SUBJECT: Wake County; Division 5; Construction of the Northern Wake  
Expressway (I-540) from US 1 to US 64; State Project No. 8.2401701;  
TIP Project No. R-2000 F&G

Attached is the modification to WQC Project No. 030114.

Re: Modification to the 401 Water Quality Certification Pursuant to Section 401 of the Federal Clean Water Act, Construction of the Northern Wake Expressway (I-540) from US 1 to US 64 in Wake County. TIP-R2000 F&G, WQC Project No. 030114 (DWQ No. for original application 960319)

SHEET **39b** OF **50** 7/3/03

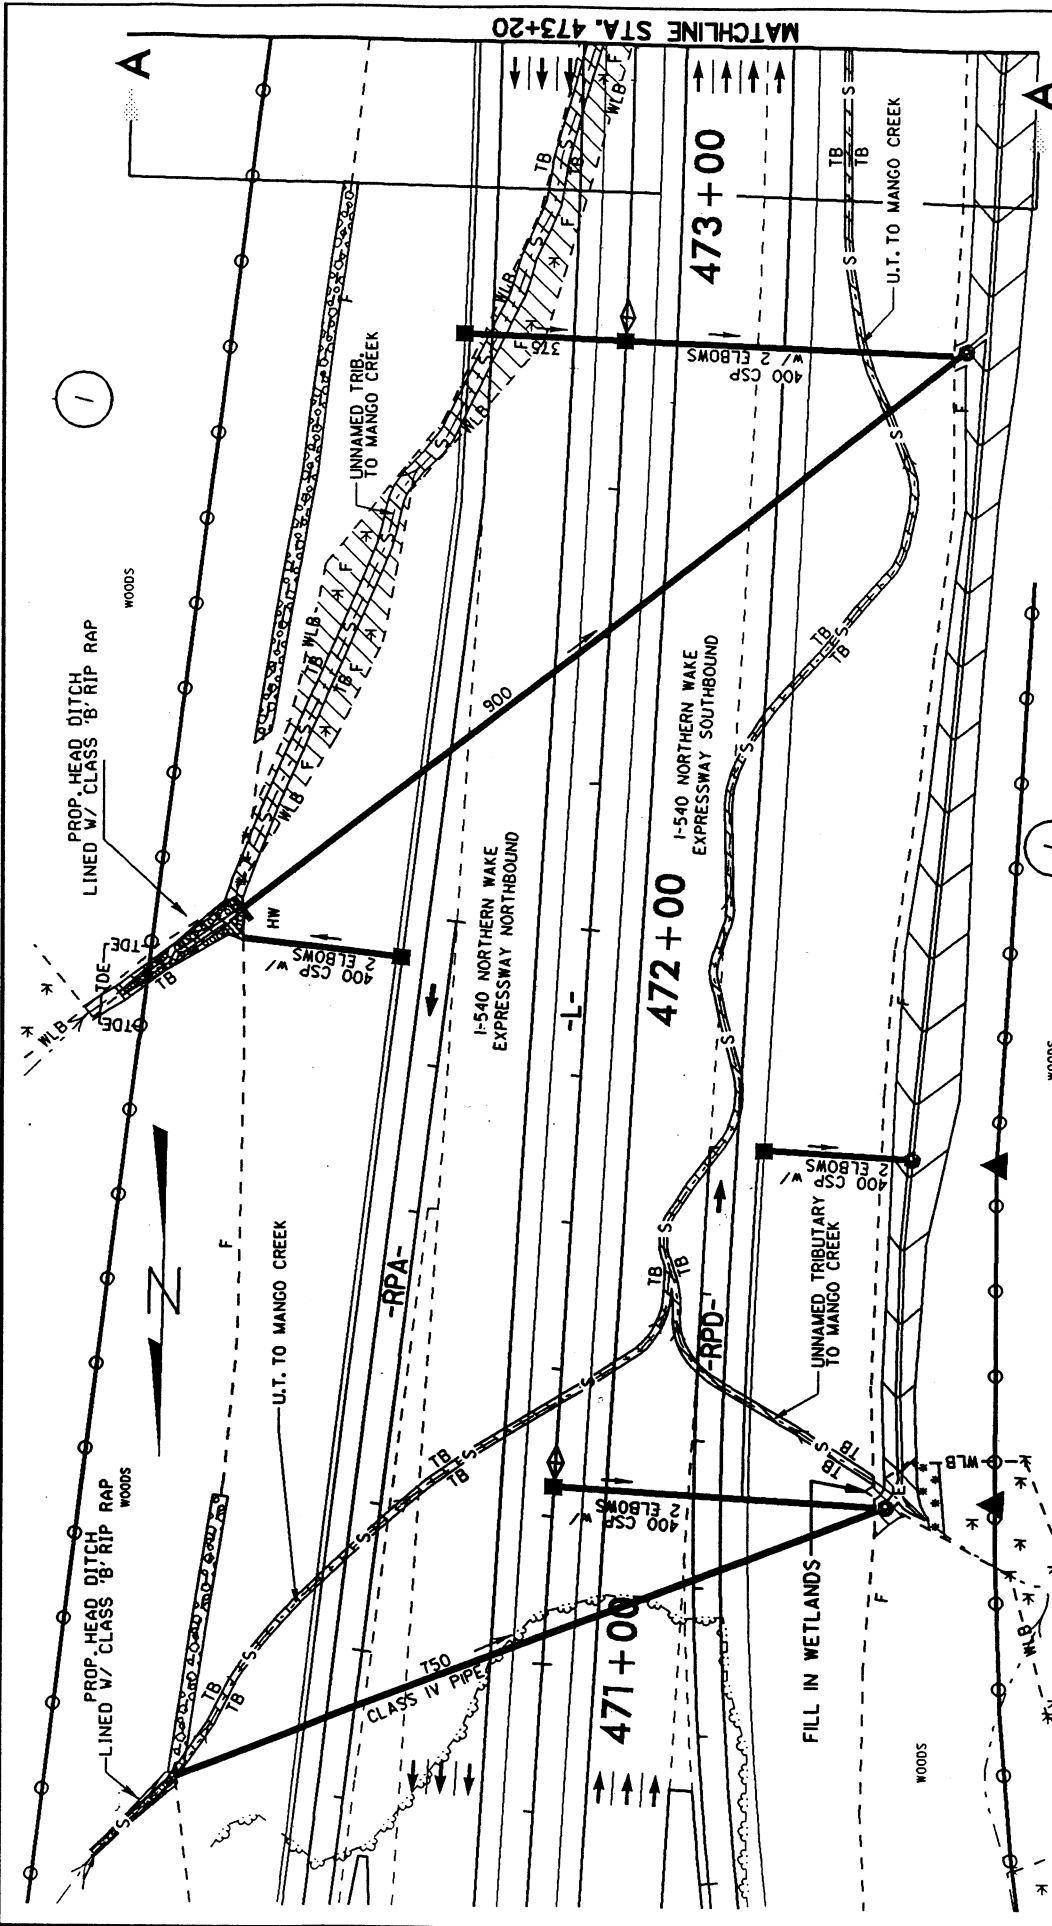
Rachelle: Per our discussion today, The modified permit drawings that NCDOT submitted on October 26, 2004 and November 4, 2004 for the subject project, specifically Sheets 39b&c of 50, revised on 10/25/04, for Site 14, and Sheet 7 of 90, revised 11/3/04 for Site 2, should be substituted in the corresponding permit drawings for this project. A formal modification of the permit will not be necessary because the 404 impacts have not changed.

This modification also approves the latest design changes submitted on October 27, 2004 and November 4, 2004, specifically adjustments to the lateral base ditch at Site 14 and a pipe shift at Site 2. This certification modifies only segments F & G of the construction of the Northern Wake Expressway (I-540) from US 1 to US 64 in Wake County and shall be constructed pursuant to the application dated received on September 28, 2004 and supplemental information dated received on October 27, 2004 and November 4, 2004. All the authorized activities and conditions of the certification associated with the original Water Quality Certification dated September 17, 1996 and all subsequent modifications still apply except where superceded by this certification.
